**National Ceramic Industries Australia – Expansion of Existing Tile Manufacturing Facility
(09_0006) – Exhibition of Environmental Assessment – Project Approval Application**

MITCHELL BENNETT
Head Major Industries Unit - Hunter Region
Environment Protection and Regulation

ATTACHMENT A**DECCW COMMENTS ON ENVIRONMENTAL ASSESSMENT
NATIONAL CERAMIC INDUSTRIES AUSTRALIA (09-0006)****1. AIR**

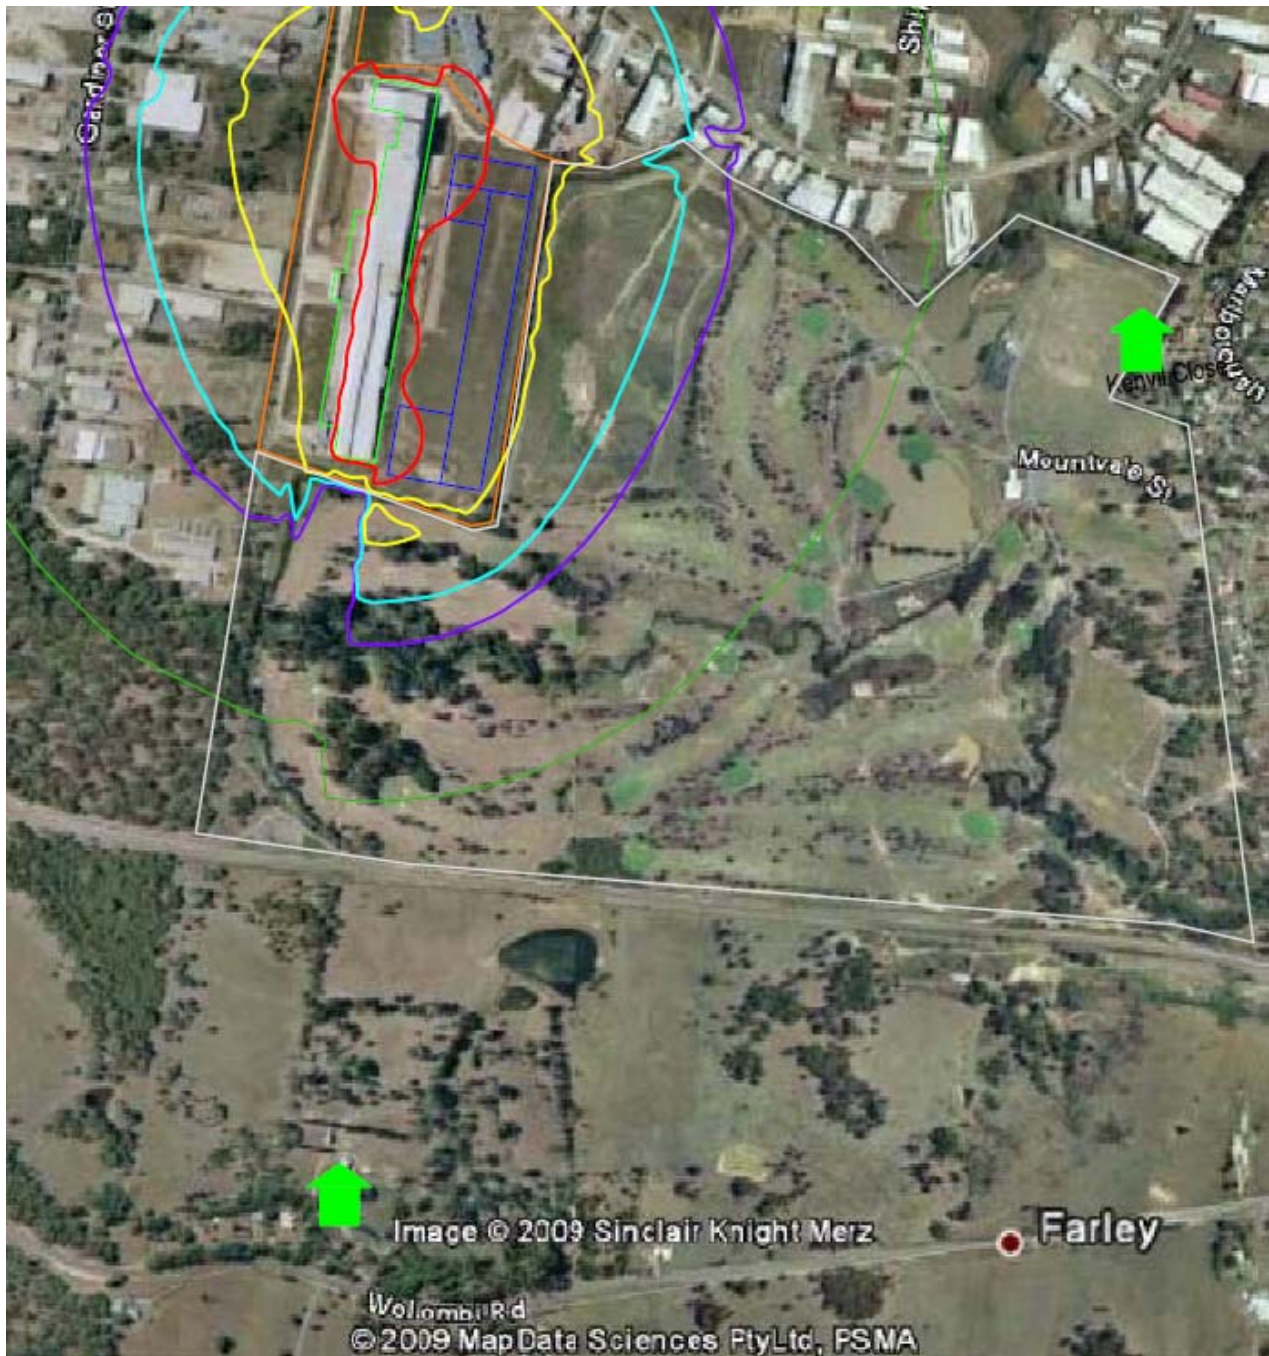
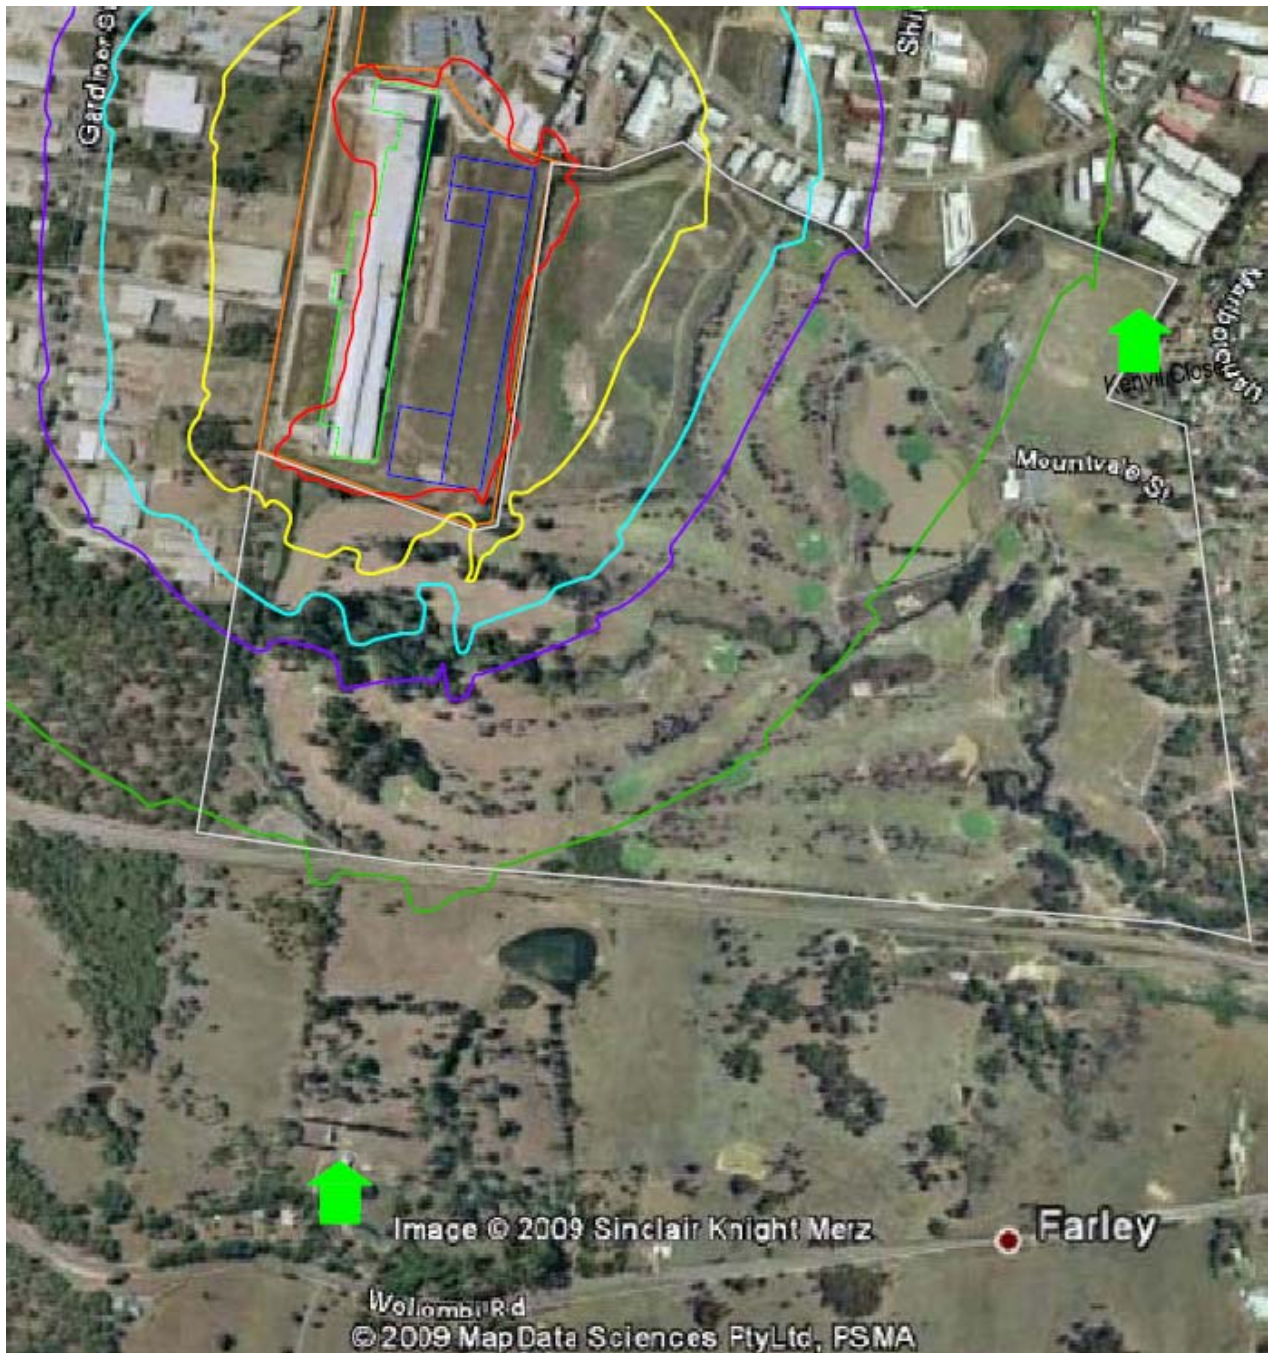
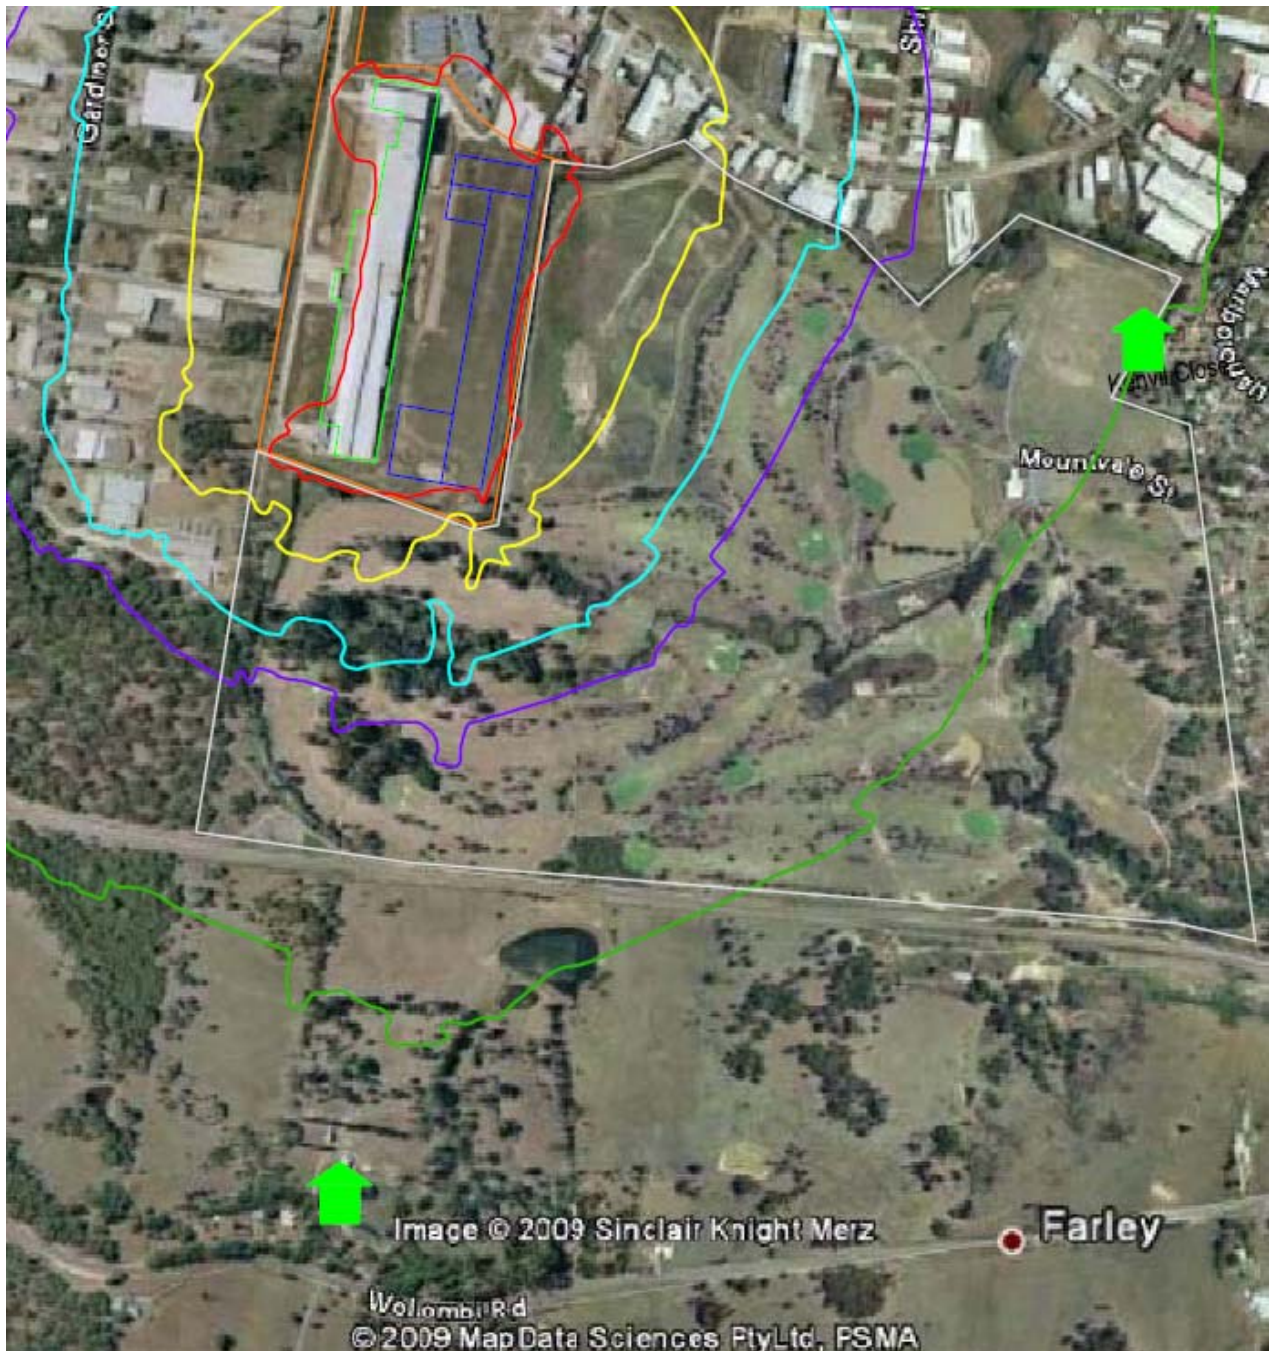
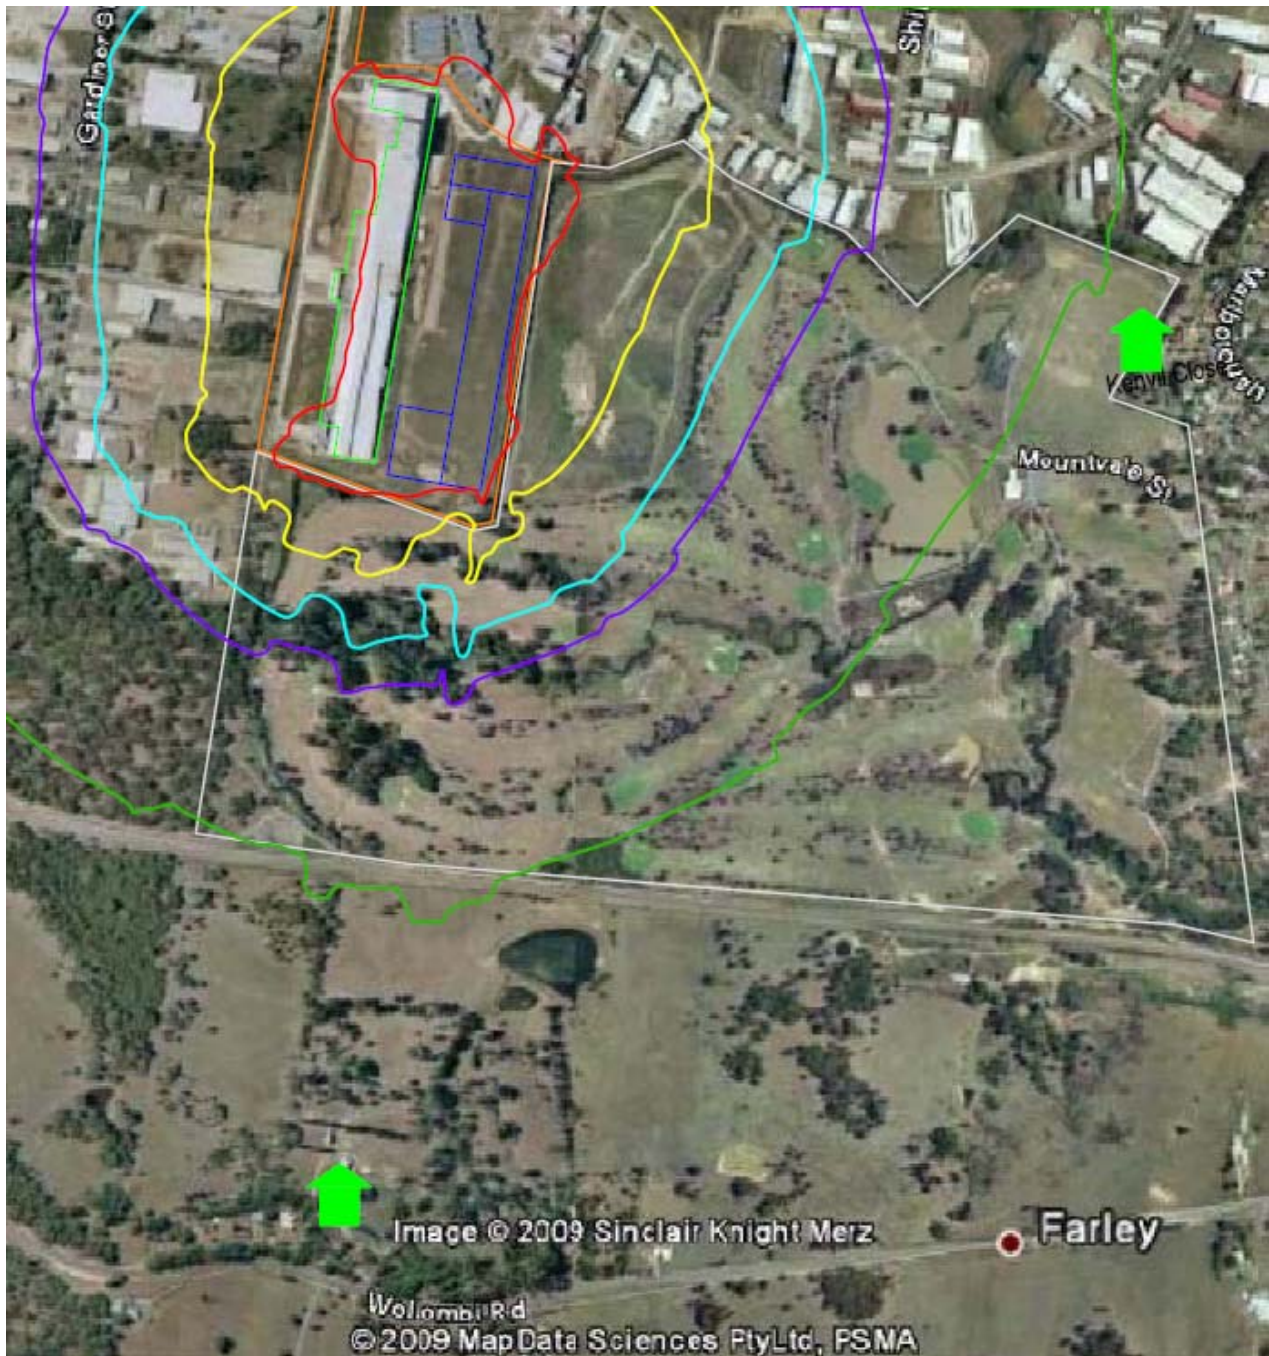
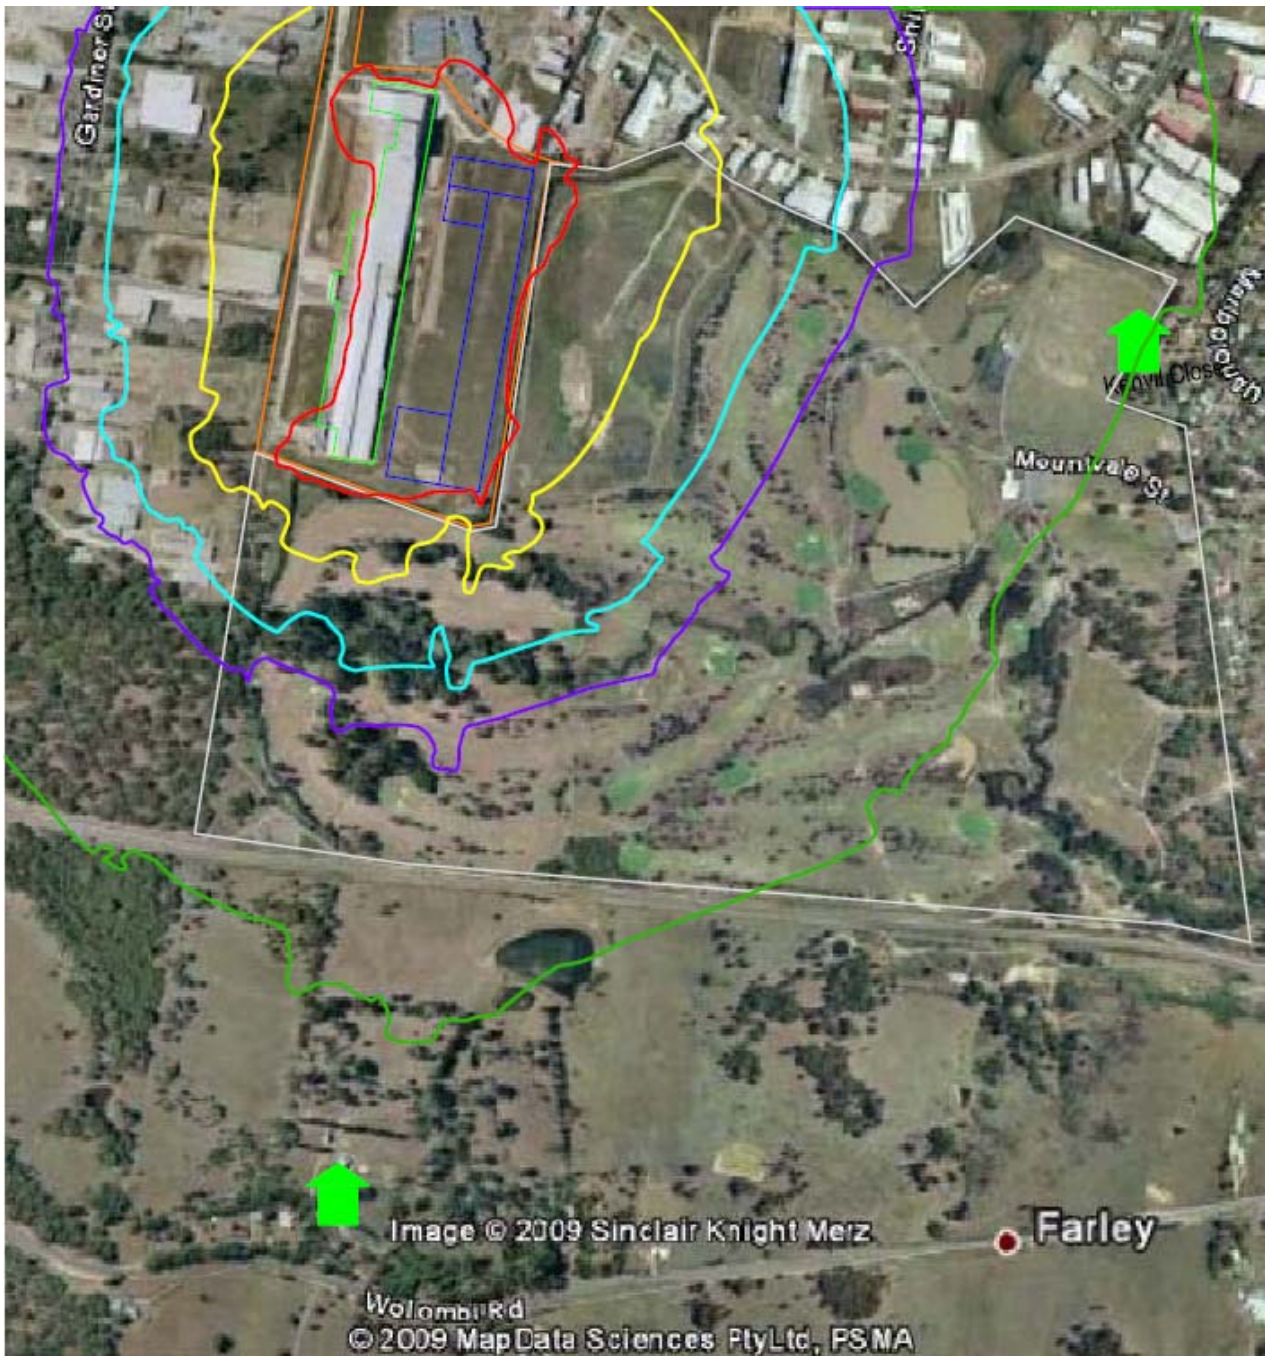
The EA appears to contain an error in the presentation of data provided in Figure 10 of the EA. Figure 10 presents predicted noise contours developed from the assessments provided by Bridges (2002) and Heggies (2009). It appears that the predicted noise level contours from the Bridges report for the existing facility are greater than the noise contour levels provided by Heggies. In essence, Figure 10 states that the noise impacts from Stages 1-4 (existing) are greater than the noise impacts from Stage 1-8 (existing plus proposed). There is no text provided to explain this.

DECCW has attempted to contact the proponent to clarify this issue, but has not been able to resolve it in the time available for comment. Accordingly DECCW recommends that the proponent be required to clarify if an error has been made in the modelling or presentation of data in Figure 10. If no explanation is provided, in accordance with the INP Noise Application Notes, DECCW will set licence limits at the predicted noise levels presented in the EA (ie limits predicted by Heggies 2009).
